From: Anita Gardner <Anita.Gardner@arun.gov.uk>
Sent: 20 October 2021 14:20
To: Planning.Responses <Planning.Responses@arun.gov.uk>
Subject: FW: AB/113/21/DOC 30 Ellis Road

Engineers comments in respect to surface water drainage;

Application No:	AB/113/21/DOC
Registered:	26th August 2021
Site Address:	30 Ellis Close Arundel BN18 9LG
Description of Works:	Approval of details reserved by condition imposed under AB/39/18/PL relating to conditions 3-Construction Management Plan, 4-surface water drainage & 5-foul & surface water sewerage disposal.

Drawing Title **Topographical Survey, Proposed Levels & Drainage GA**

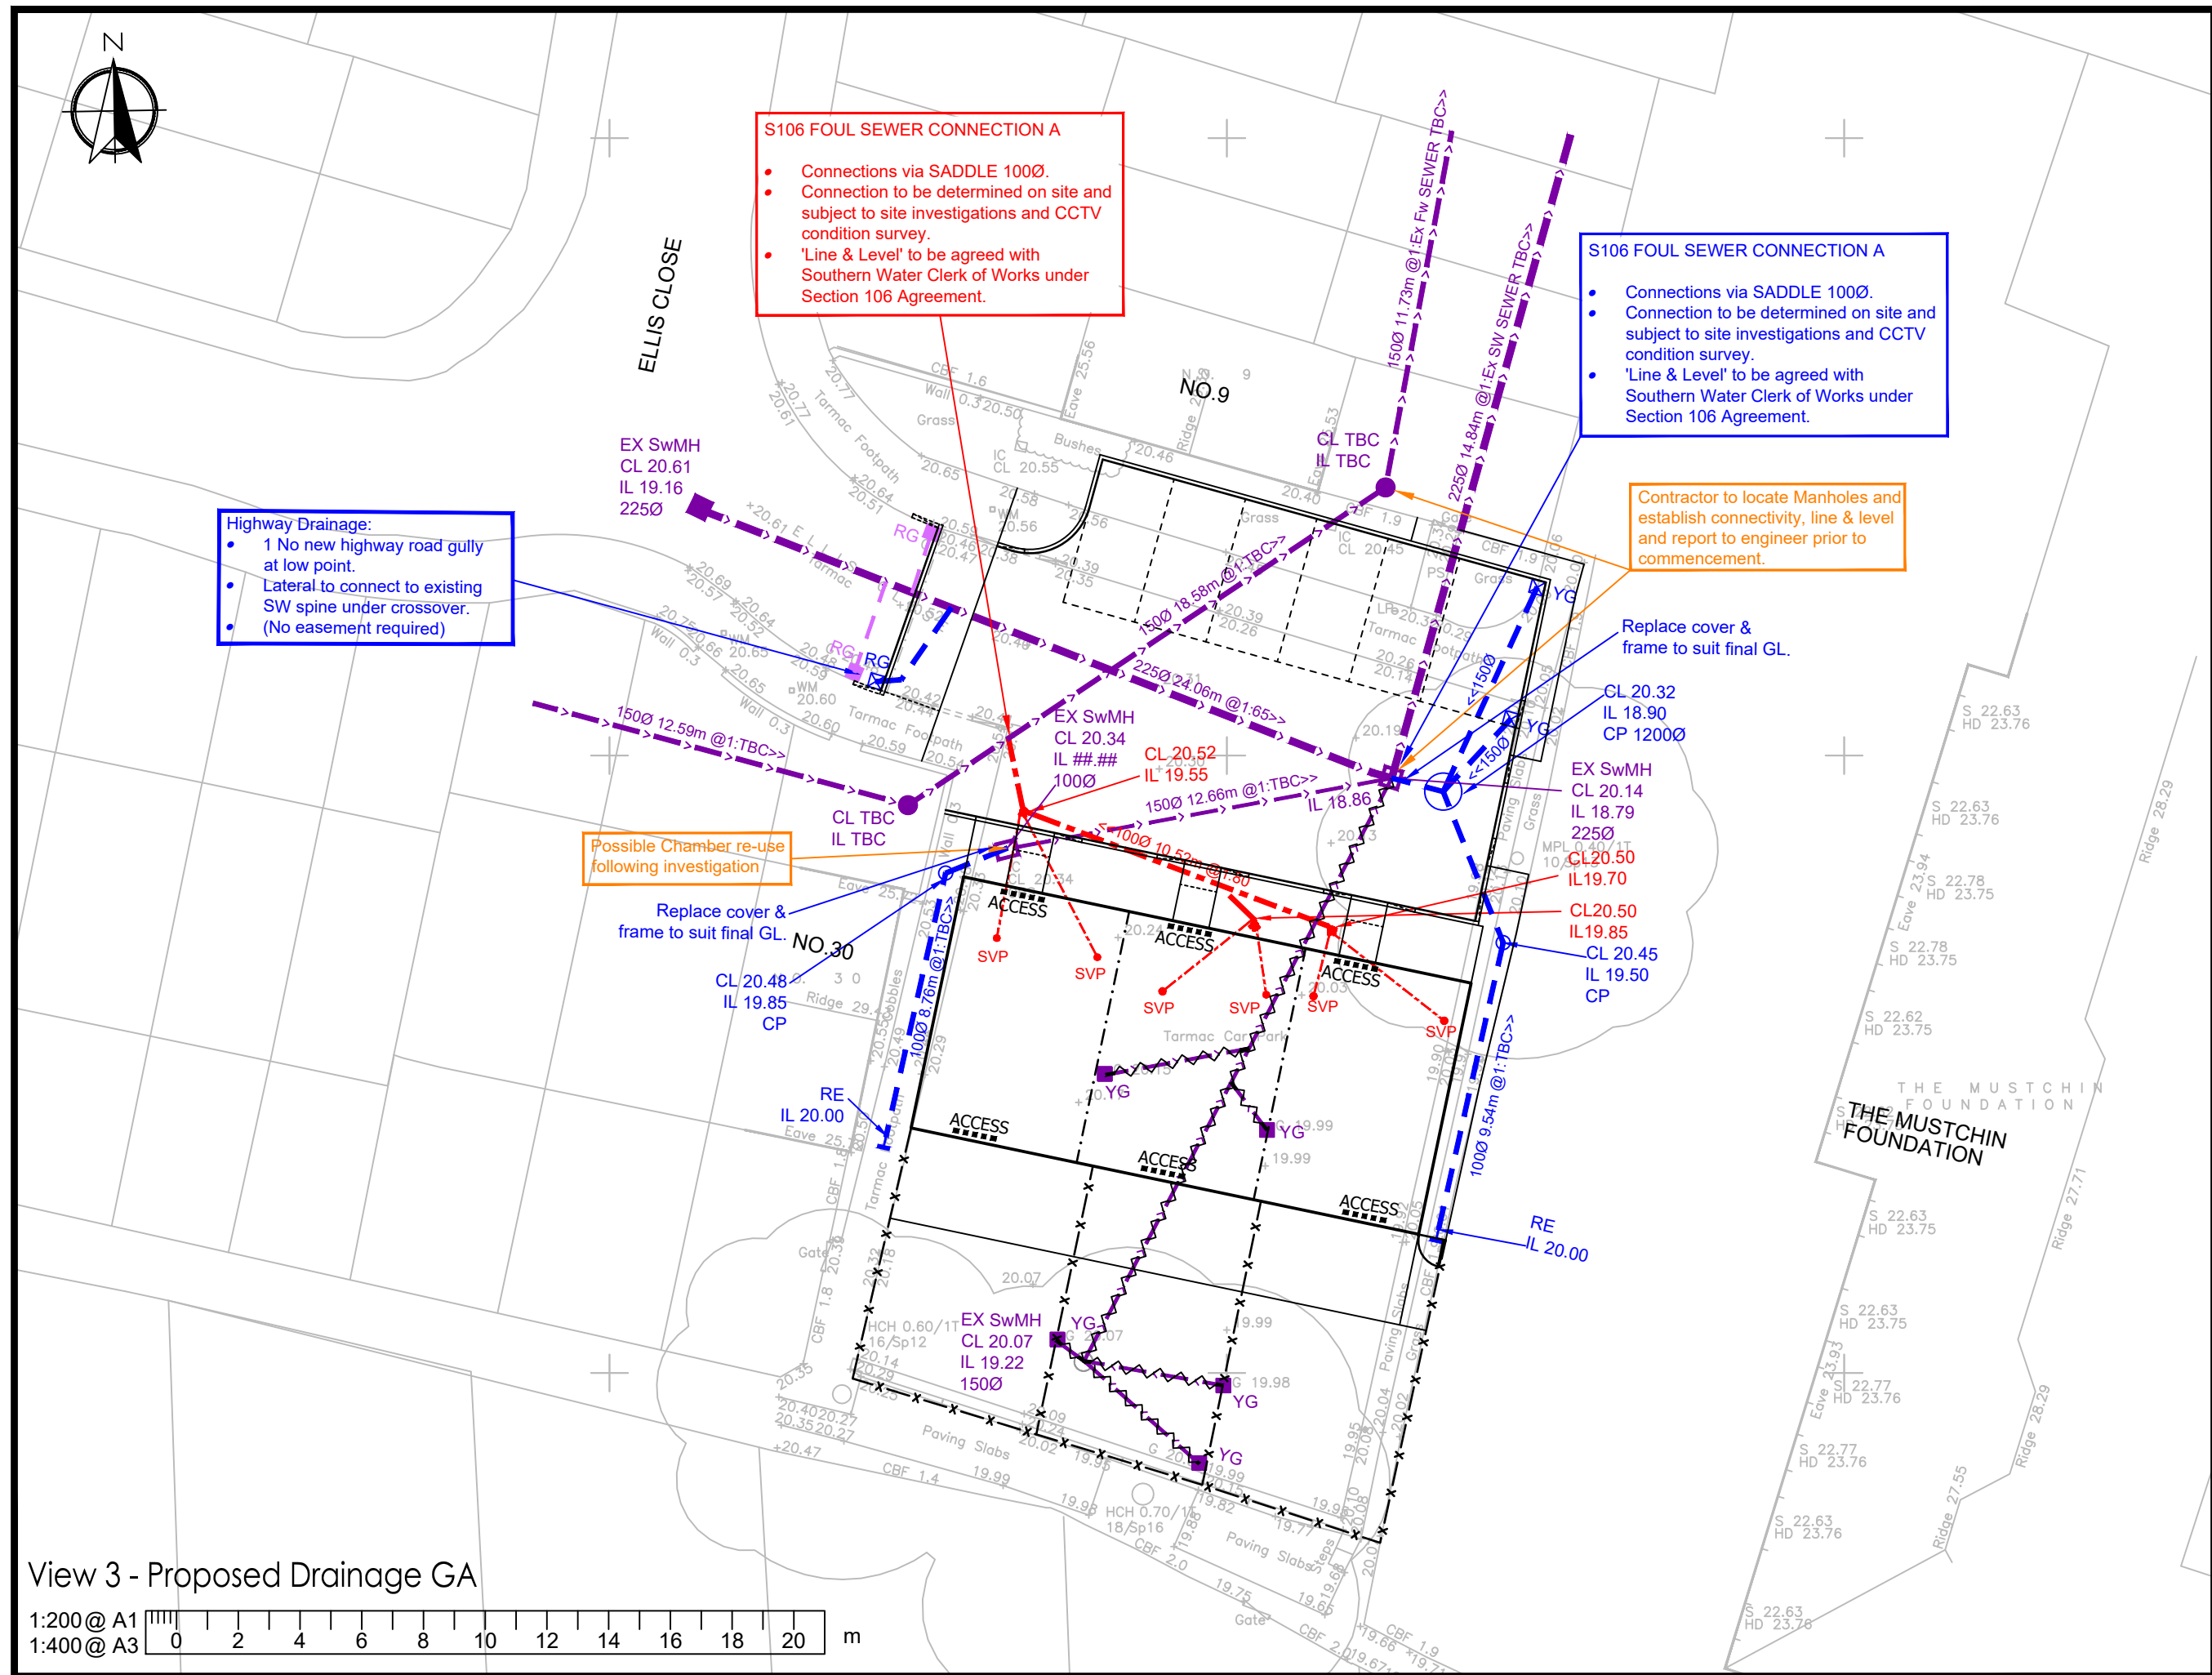
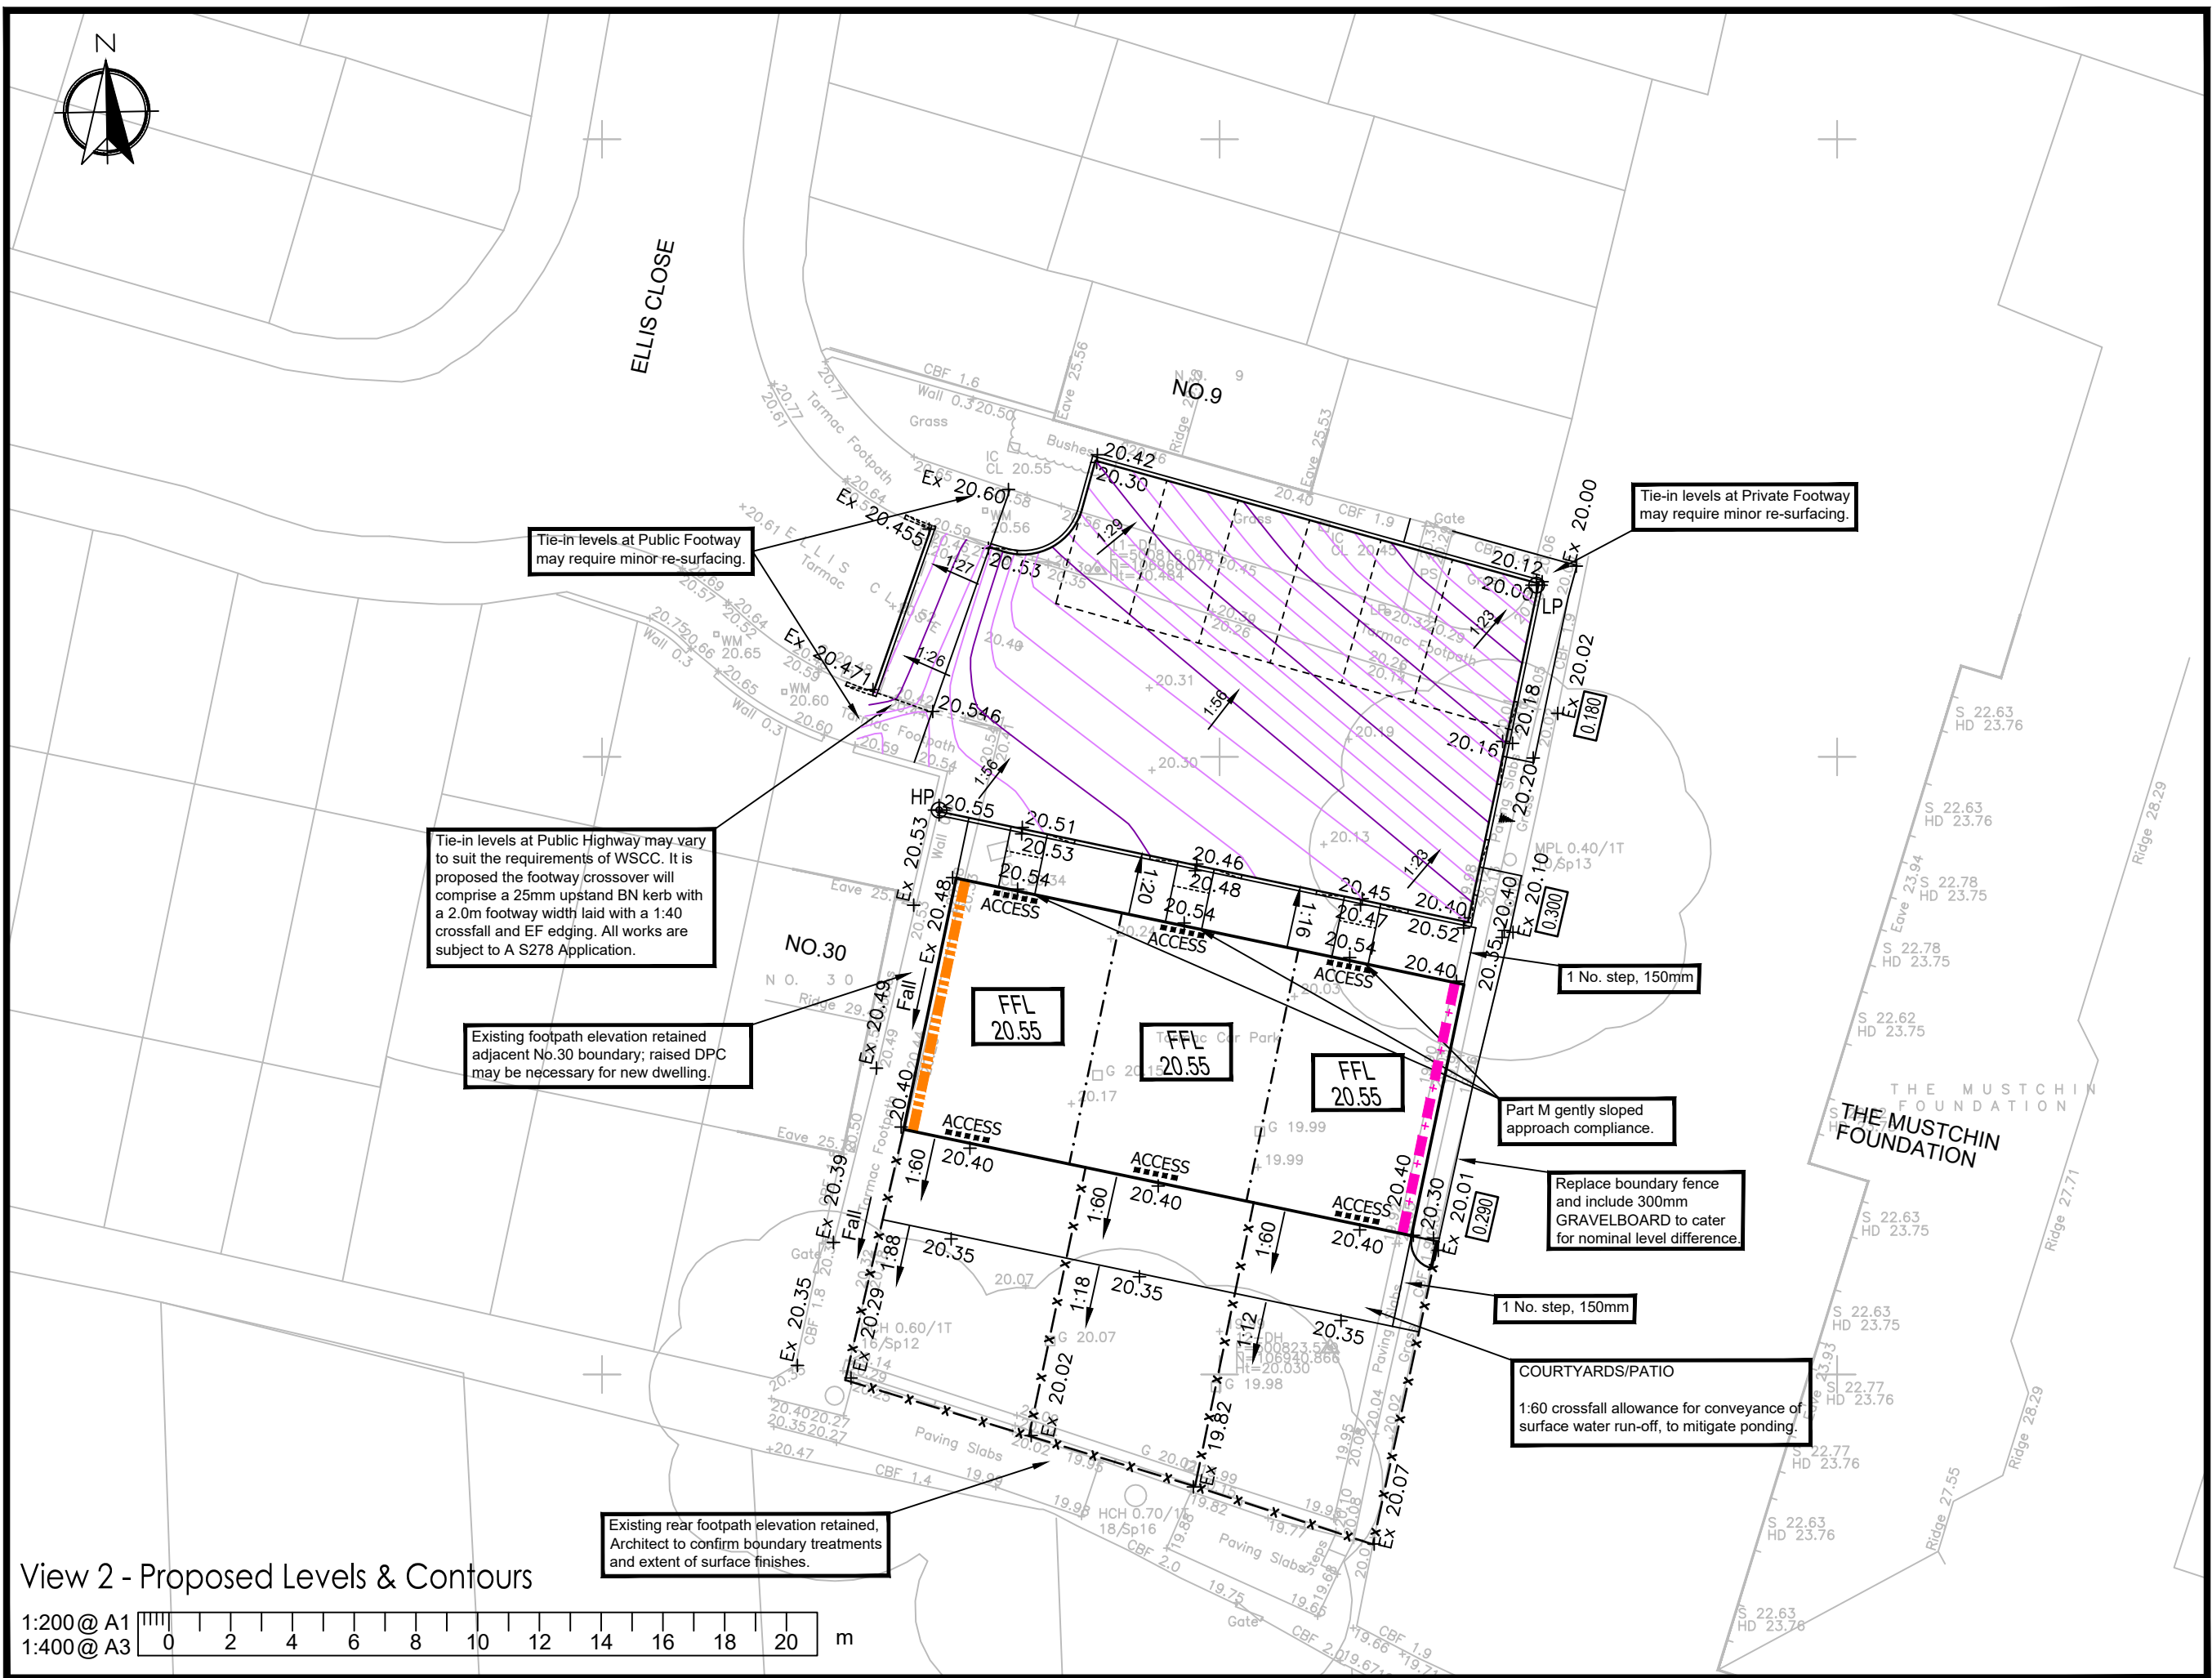
1. On the assumption that the surface water sewer being connected to is deemed vested under 2011 legislation, please provide evidence of Southern Water's approvals to the connections.
2. New highway gully to be connected via oblique junction – add note.
3. Connections to be made to existing manholes (2no.) to be made at soffit to soffit level – indicate level and connecting pipe diameter.
4. Upgrade yard gullies to road gullies to provide increased resilience.
5. Where existing surface water drain is to be grubbed up – add note that manhole is to be made good inside.
6. Proposed manhole cover replacements (2no.) to be ductile iron. Please also specify loading grade.
7. Show rainwater pipes including points of connection. Connections to be made to manholes where possible or via oblique junctions.

8. Note referring to the proposed connection to the existing manhole in the car park area refers to a saddle connection and 'foul'. Please adjust note.
9. 1200mm catchpit construction detail – specify ductile iron cover/frame & polypropylene coated step rungs/irons.
